Site Development Plan.pdf Markup Summary

[1] S-1 Site Development Plan (9)

Subject: Planner
Page Label: [1] S-1 Site Development Plan
Author: dsdparsons

ARCHITECTURAL SITE PLAN

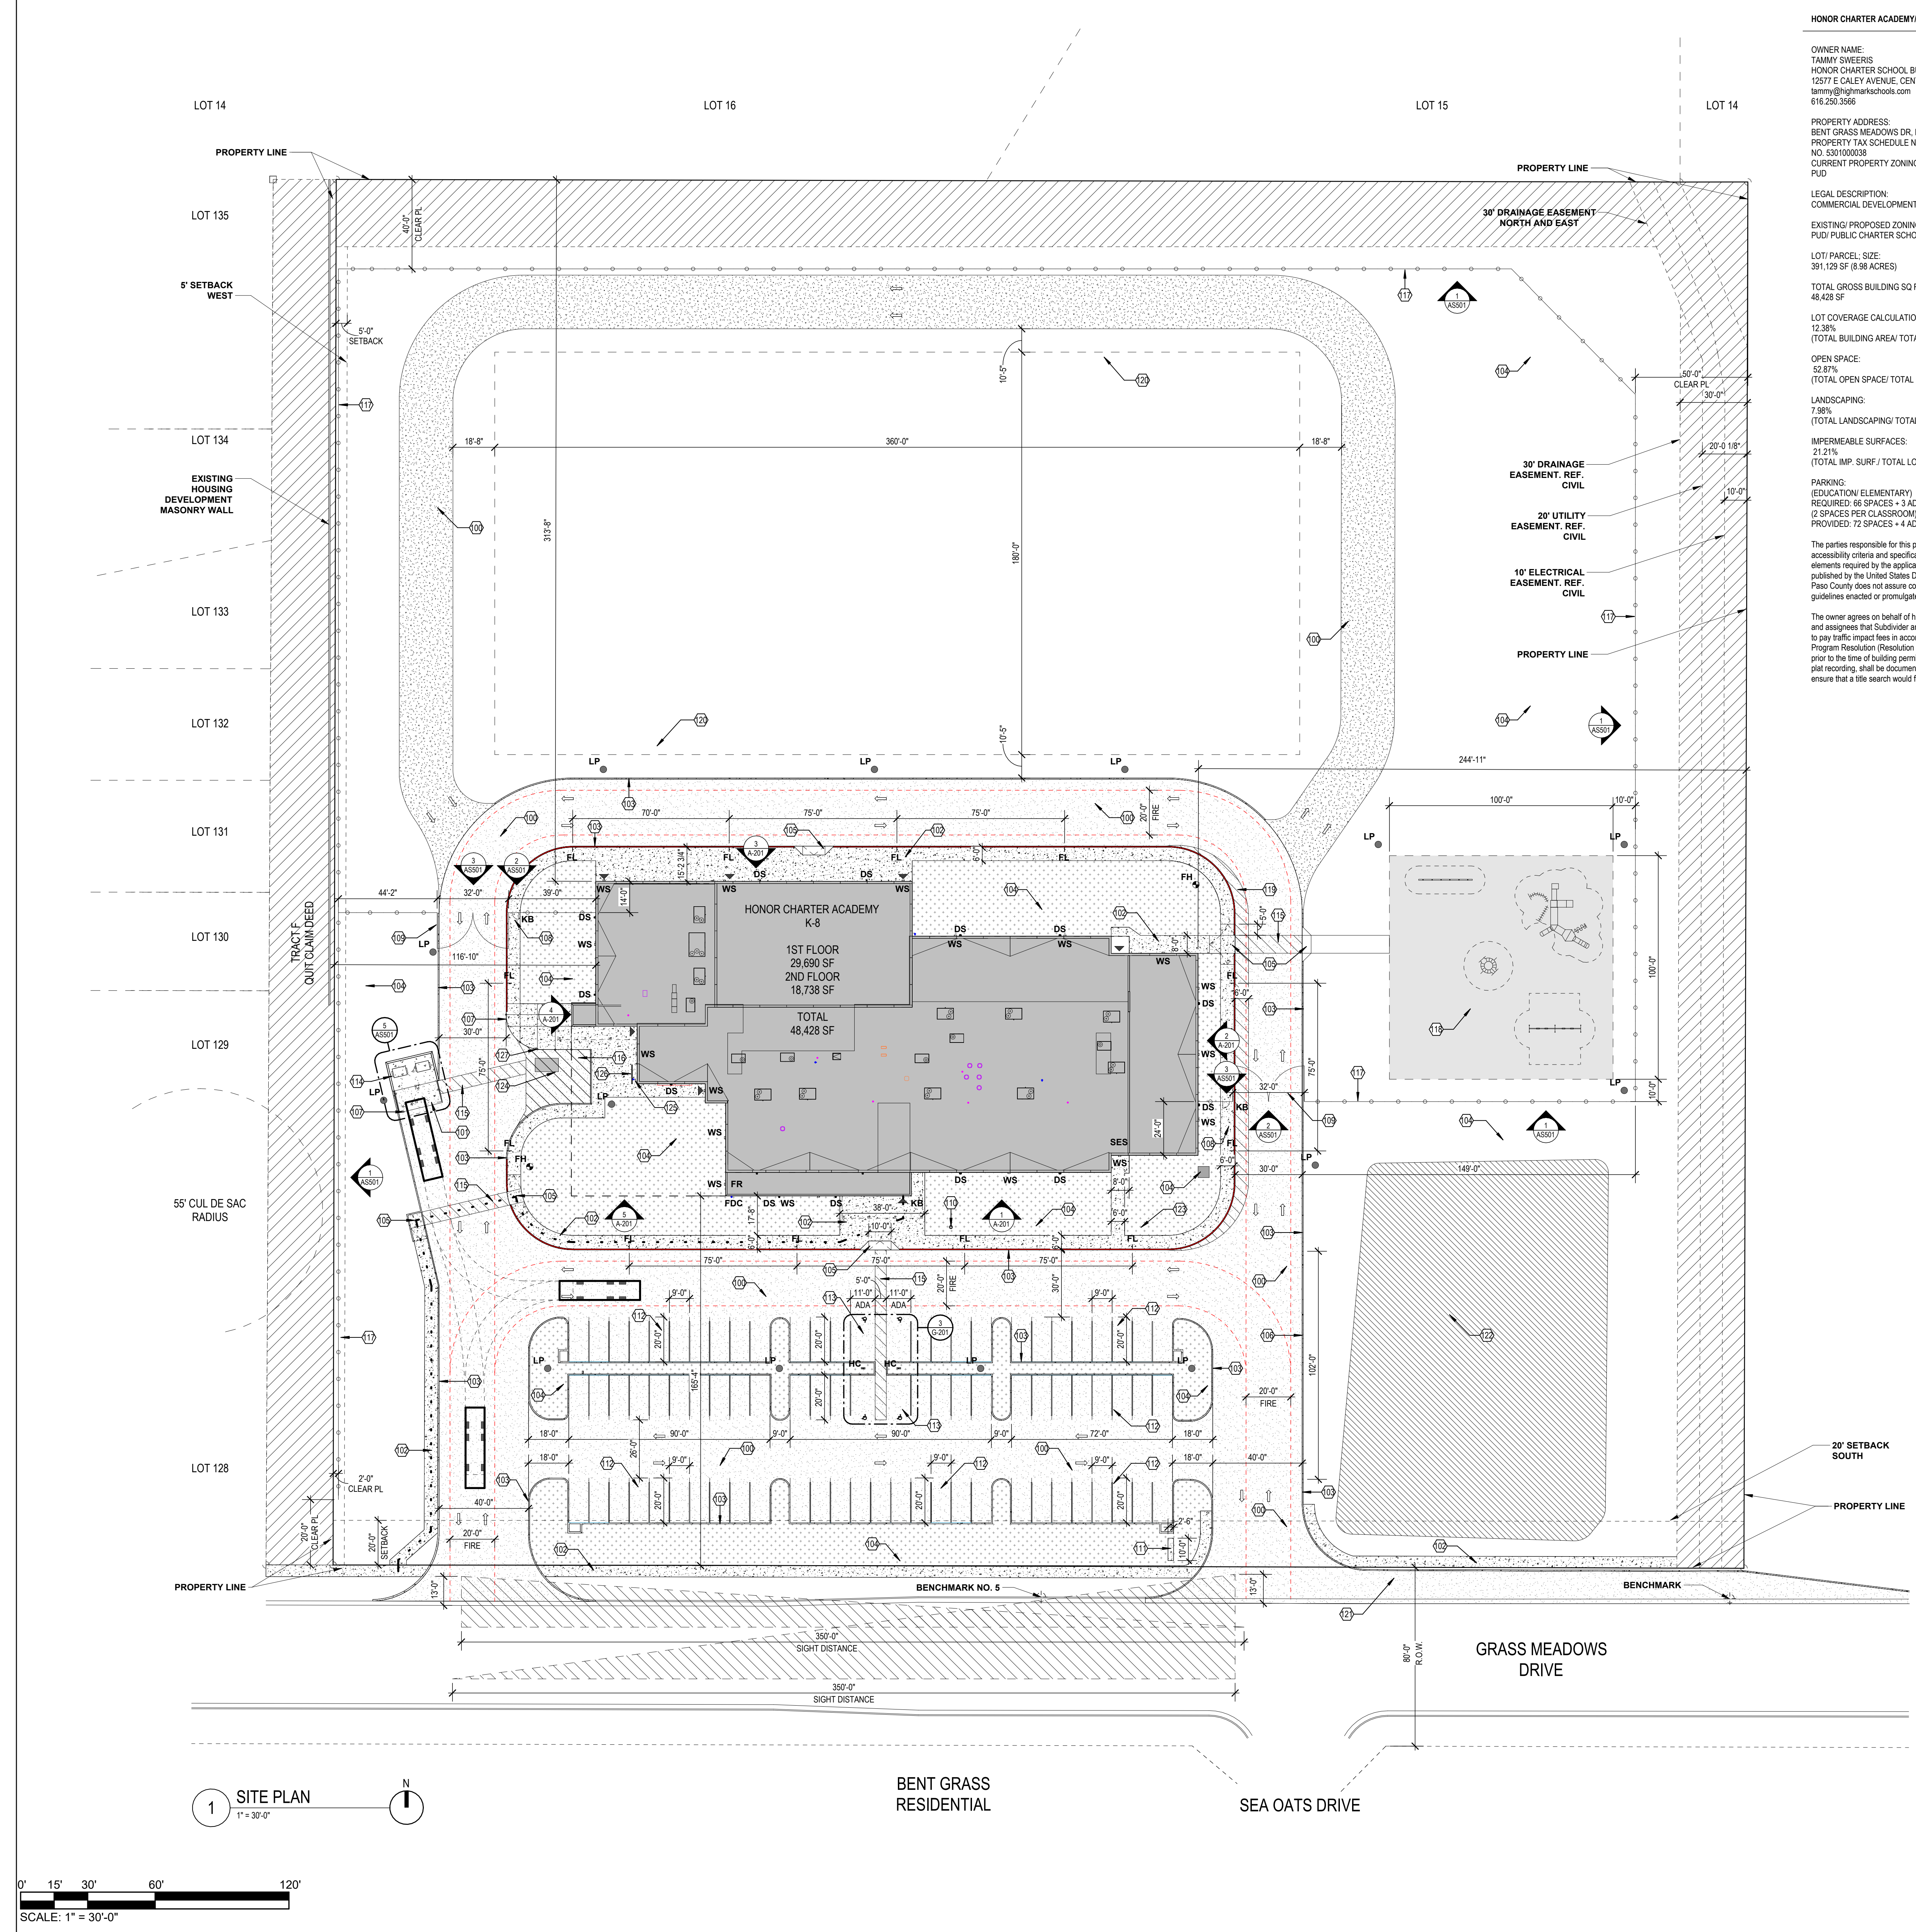
Show all property lines and depict 25 foot building setbacks per the checklist and provide landscape , buffer setbacks per Chapter 6

REVIEW 1 comment
still not addressed
25' /building
setbacks

REVIEW 1 comment still not
addressed 25' /building setbacks

Move out of 25' setback- review
1 comment not addressed

Please consider relocating this trash facility away from the residents and please meet the 25 setbacks as required.

25'

add numbers for each setback review 1 comment not addressed

buffer is 15' landscape setback on west and east and north; 20 on Bent Grass;

BSLS CHANGED TO 25 FEET. PER CHAPTER 6 OF THE LDC, THE BUFFER SHOULD BE 15 FEET ALONG BENT GRASS MEADOWS AS IT IS A NON-ARTERIAL ROAD SEPARATING FROM RESIDENTIAL TO THE SOUTH. ALL LANDSCAPE SETBACKS HAVE BEEN SET TO 15 FEET.

BUILDING SETBACKS HAVE BEEN CHANGED TO 25 FEET AND LABELED ACCORDINGLY.

TRASH ENCLOSURE HAS BEEN ROTATED AND MOVED OUT OF THE 25' BUILDING SETBACK.

TAIT RESPONSE:
TRASH ENCLOSURE HAS BEEN ROTATED AND MOVED OUT OF THE 25' BUILDING SETBACK.

TAIT RESPONSE:
SETBACK LINES HAVE BEEN LABELED ACCORDINGLY. ("25' BSL", "15' LSL").

TAIT RESPONSE:
SETBACK LINES HAVE BEEN LABELED ACCORDINGLY. ("25' BSL", "15' LSL").

TAIT RESPONSE:
PER CHAPTER 6 OF THE LDC, THE BUFFER SHOULD BE 15 FEET ALONG BENT GRASS MEADOWS AS IT IS A NON-ARTERIAL ROAD SEPARATING FROM RESIDENTIAL TO THE SOUTH. ALL LANDSCAPE SETBACKS HAVE BEEN SET TO 15 FEET.

5 TRASH ENCLOSURE FLOOR PLAN
1/4" = 1'-0"

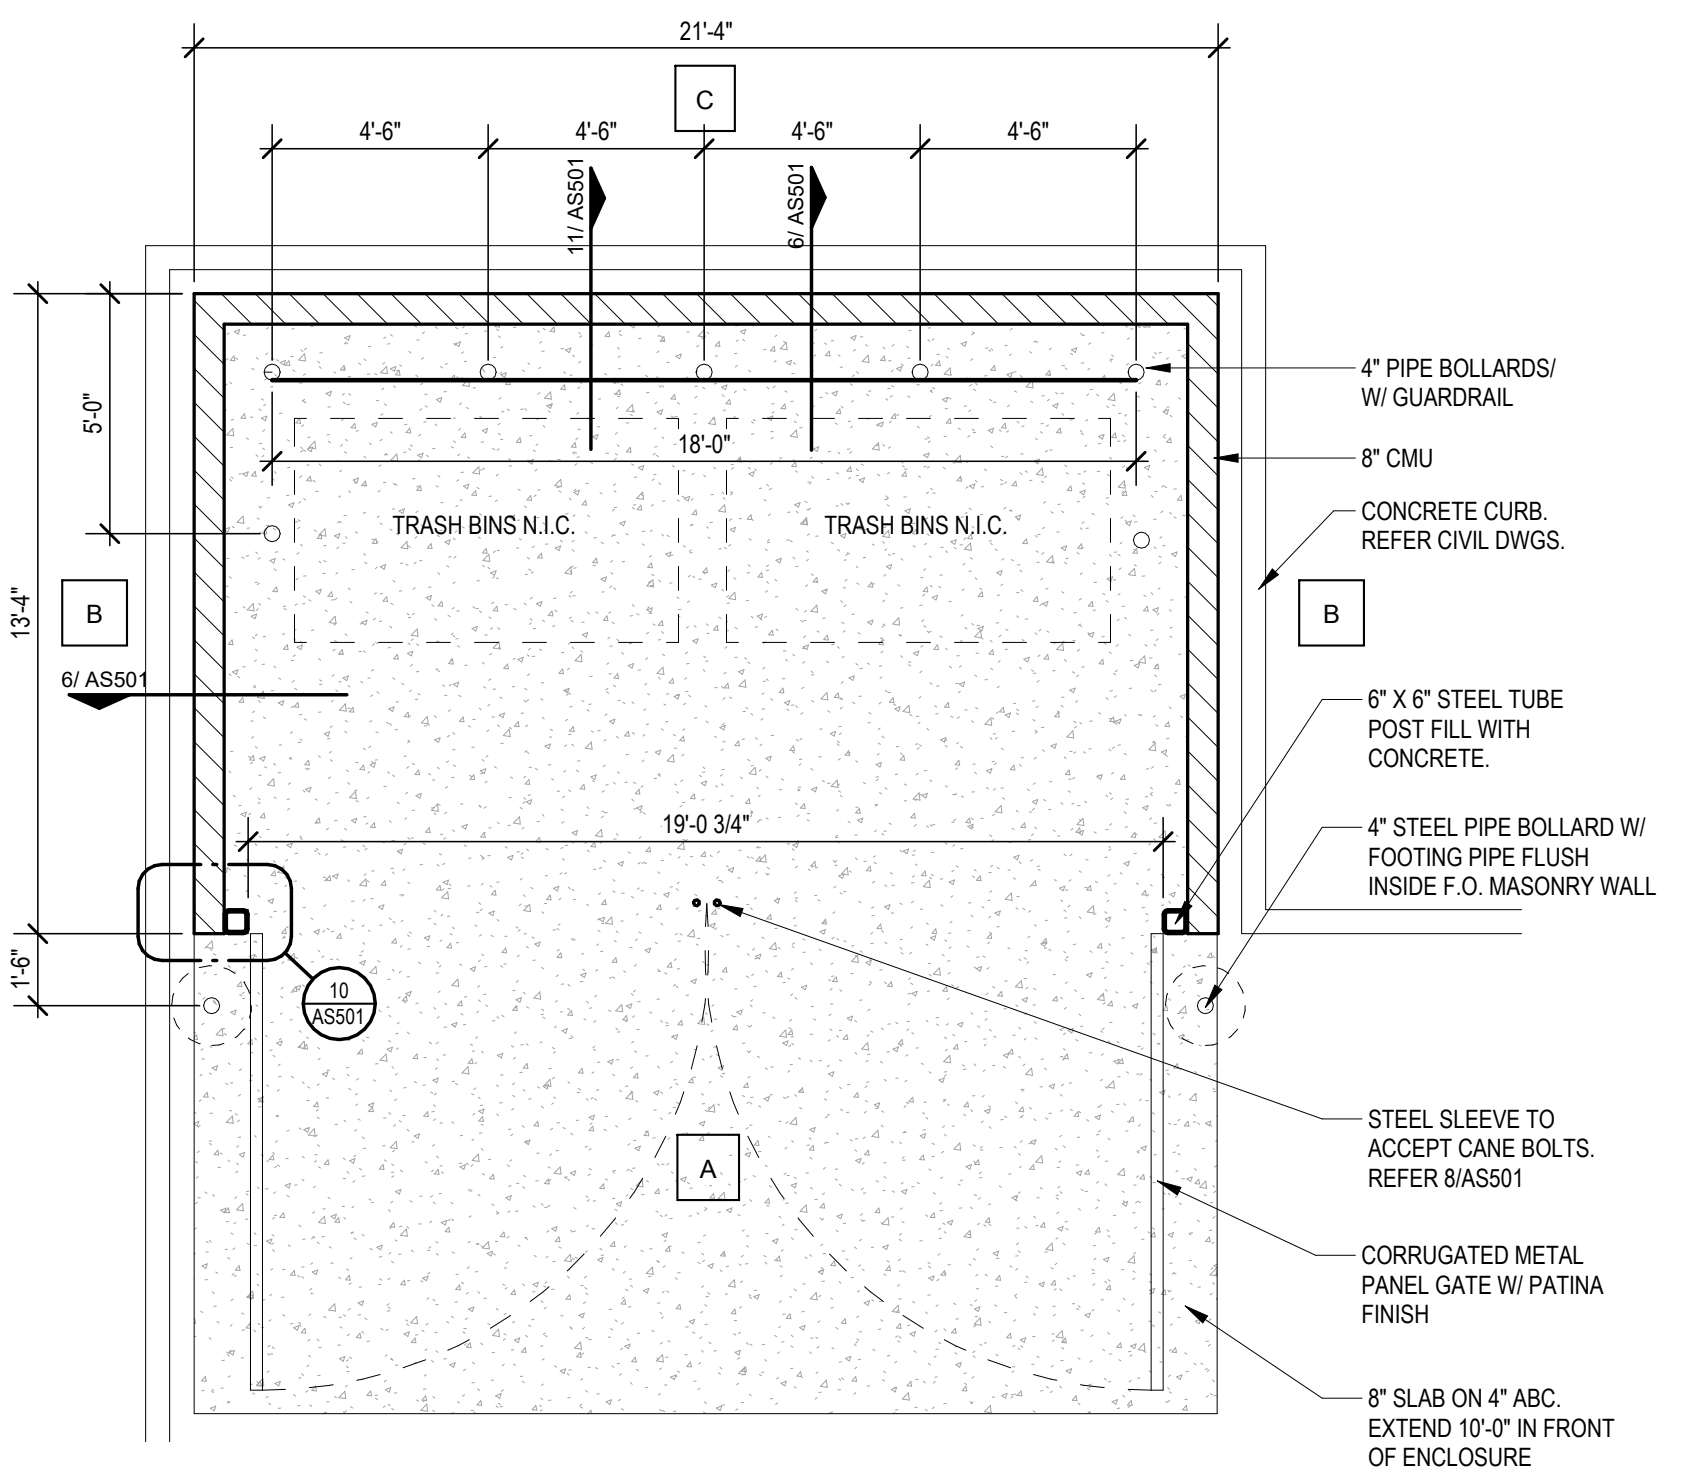
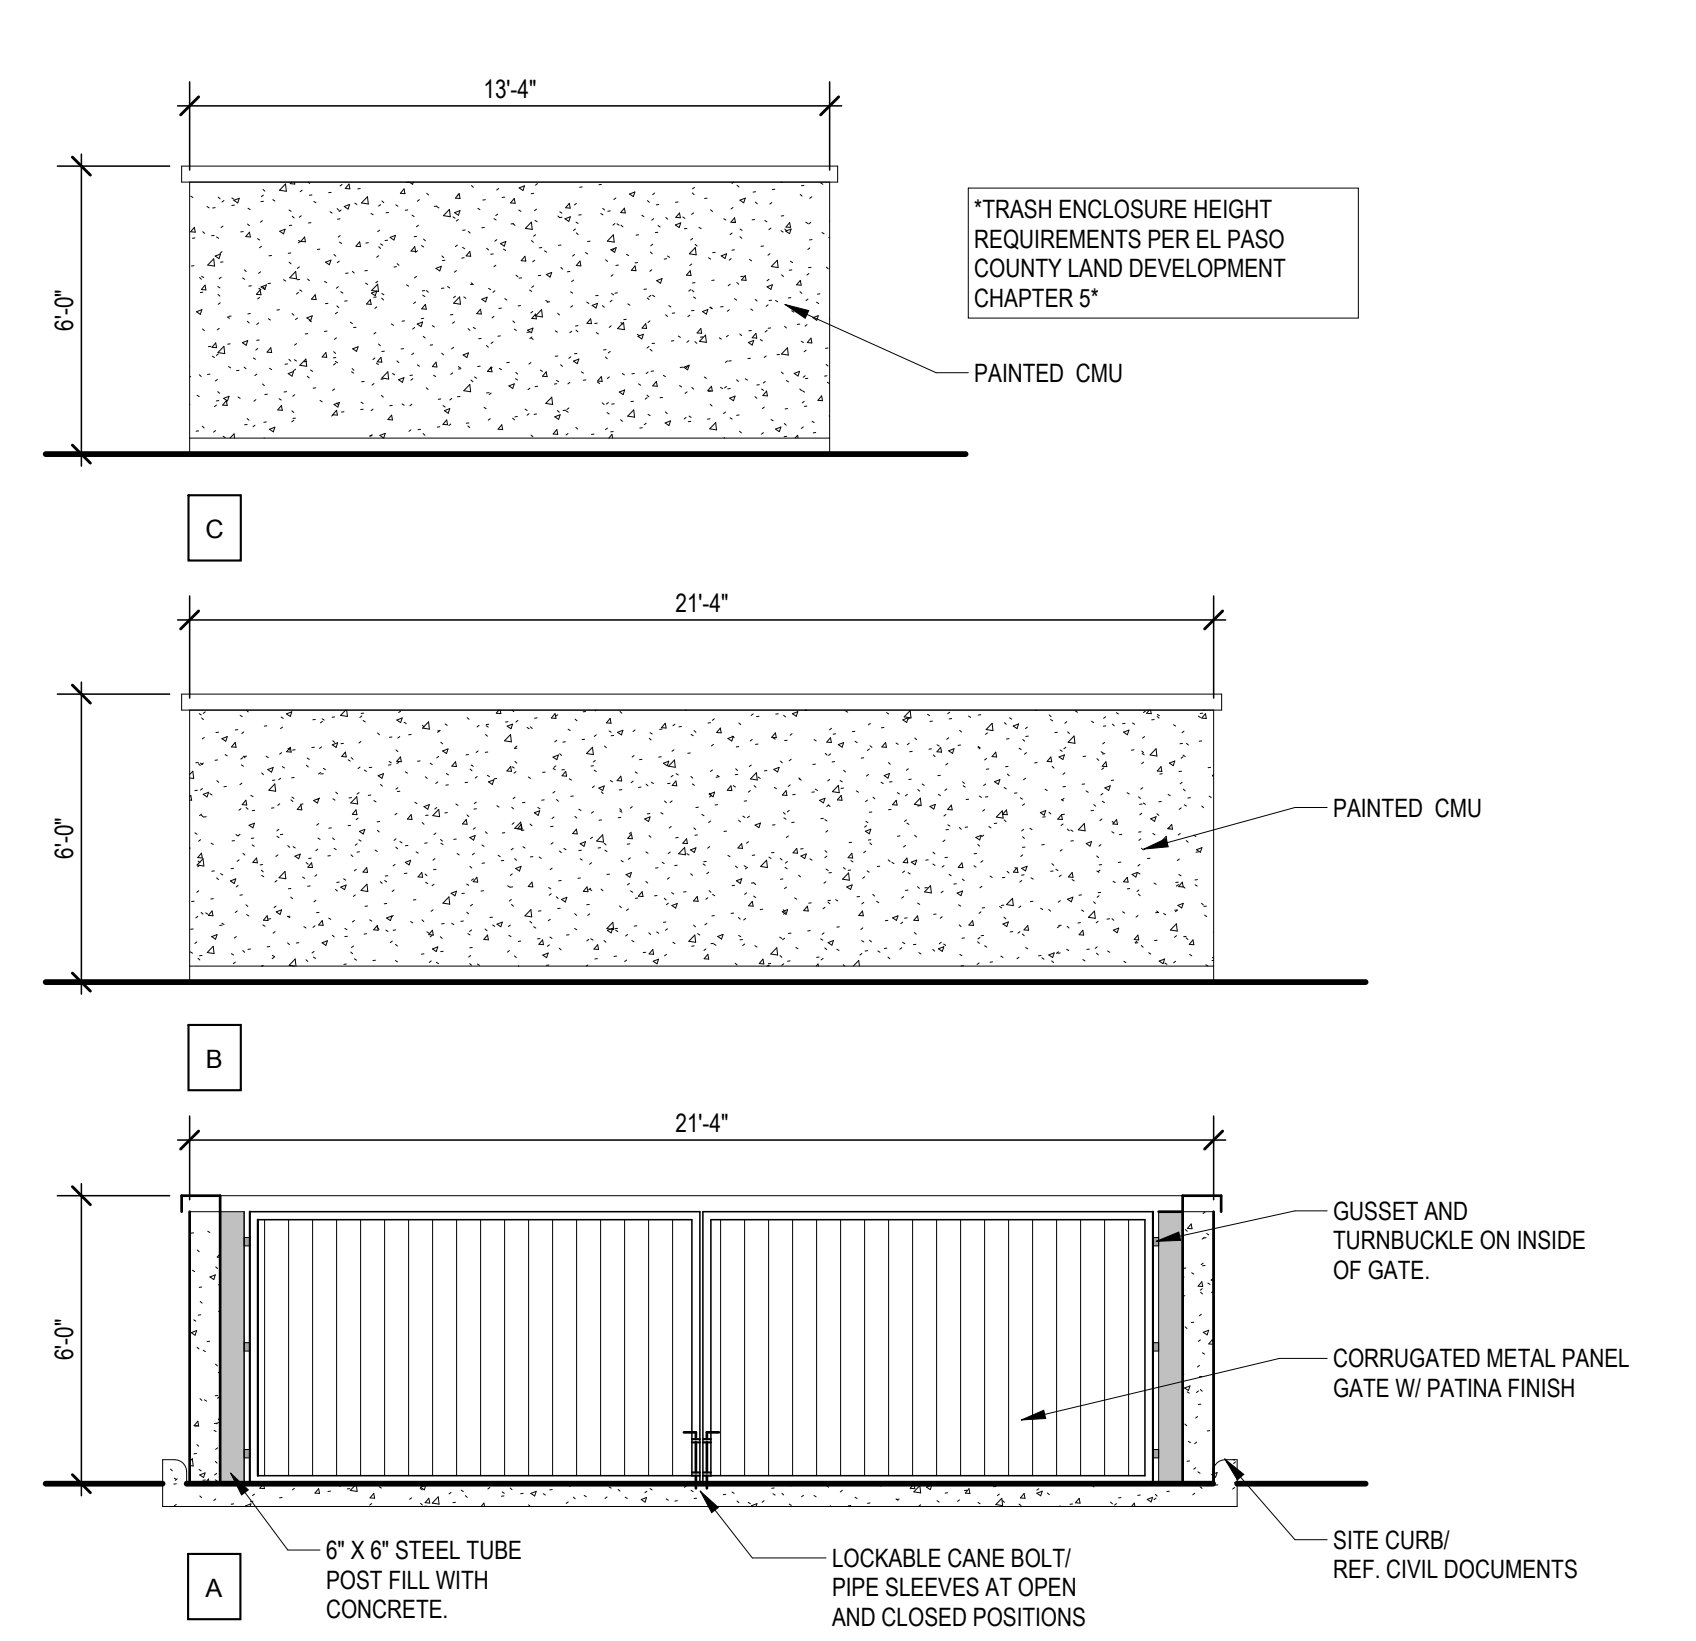
Add trash enclosure detail; it must be 100% enclosed with CMU, concrete, stucco to this set.

Add trash enclosure detail; it must be 100% enclosed with CMU, concrete, stucco.

TRASH ENCLOSURE DETAILS HAVE BEEN ADDED TO THE SET. ADDITIONAL DETAILS ARE ALSO INCLUDED IN THE ARCHITECTURAL SET AND ARE REFERENCED ACCORDINGLY.

TAIT RESPONSE:
TRASH ENCLOSURE ADDED AND IS ENCLOSED WITH CMU.
